Black Forest Meadows Outdoor Wedding Venue Concept Plan April 7, 2021

PCD File No. VA-21-001

# Black Forest Meadows Outdoor Wedding Venue Concept Plan April 6, 2021

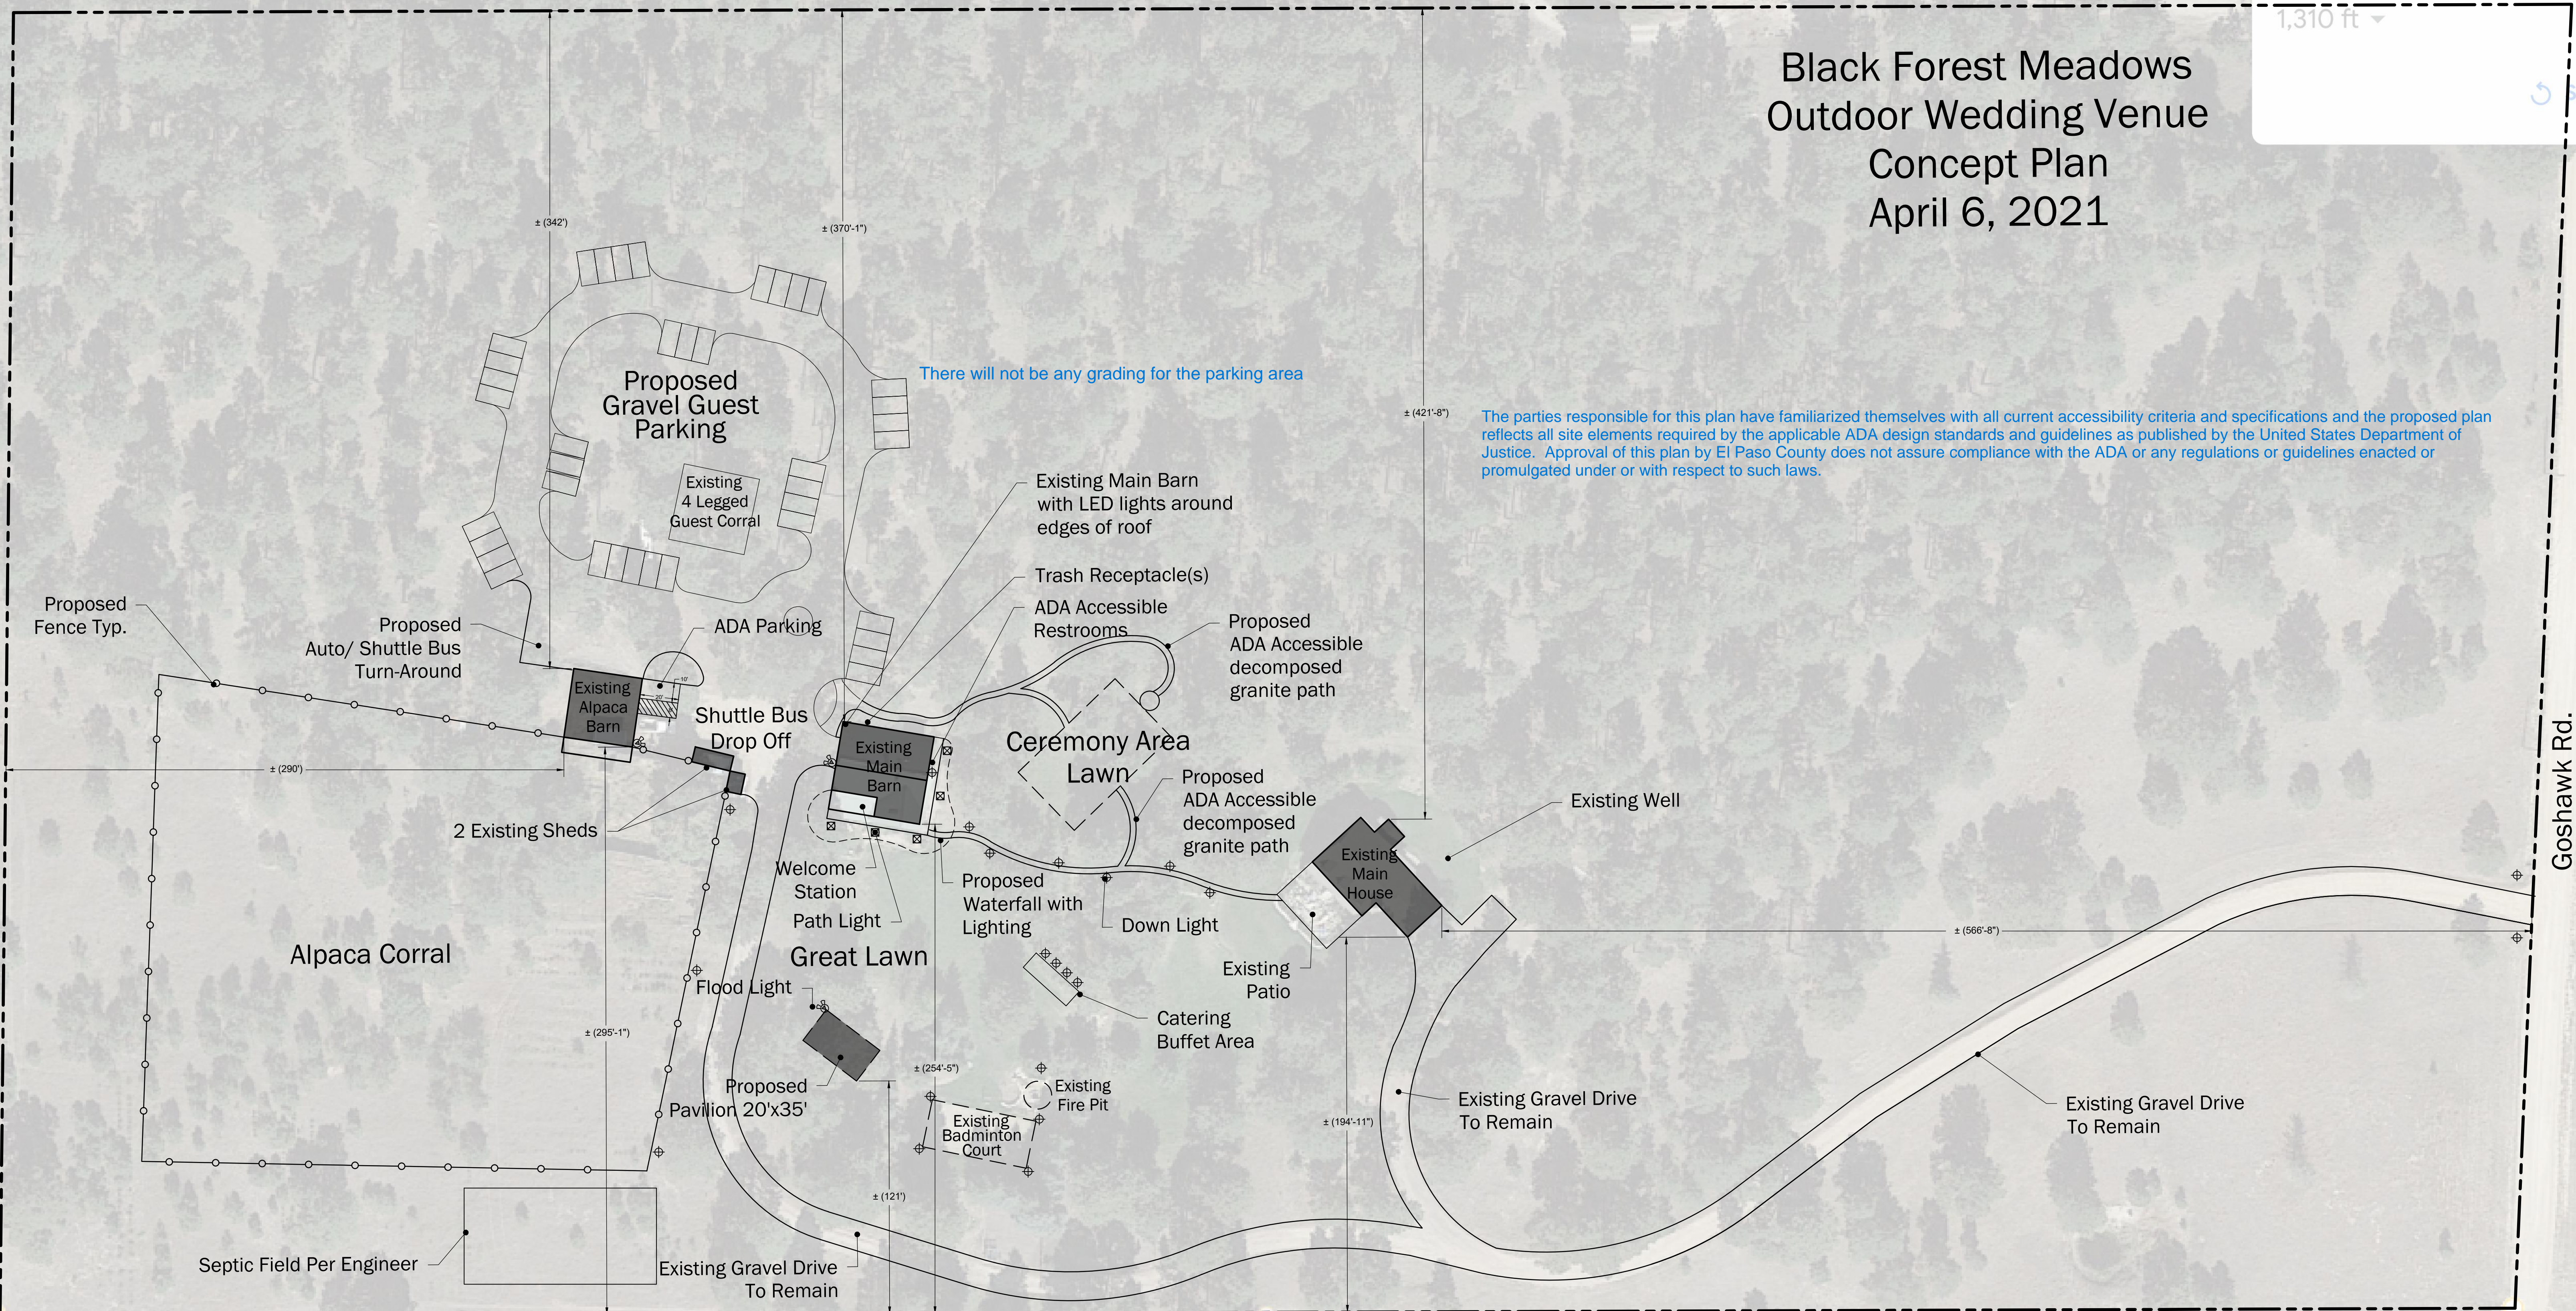
The following note should be added to all site development plans or non-residential site plans, as applicable, prior to PCD approval:
The parties responsible for this plan have familiarized themselves with all current accessibility criteria and specifications and the proposed plan reflects all site elements required by the applicable ADA design standards and guidelines as published by the United States Department of Justice. Approval of this plan by El Paso County does not assure compliance with the ADA or any regulations or guidelines enacted or promulgated under or with respect to such laws.

Please label approximately how much grading is being proposed for parking lot.

Please update PCD File No. to PPR-21-049
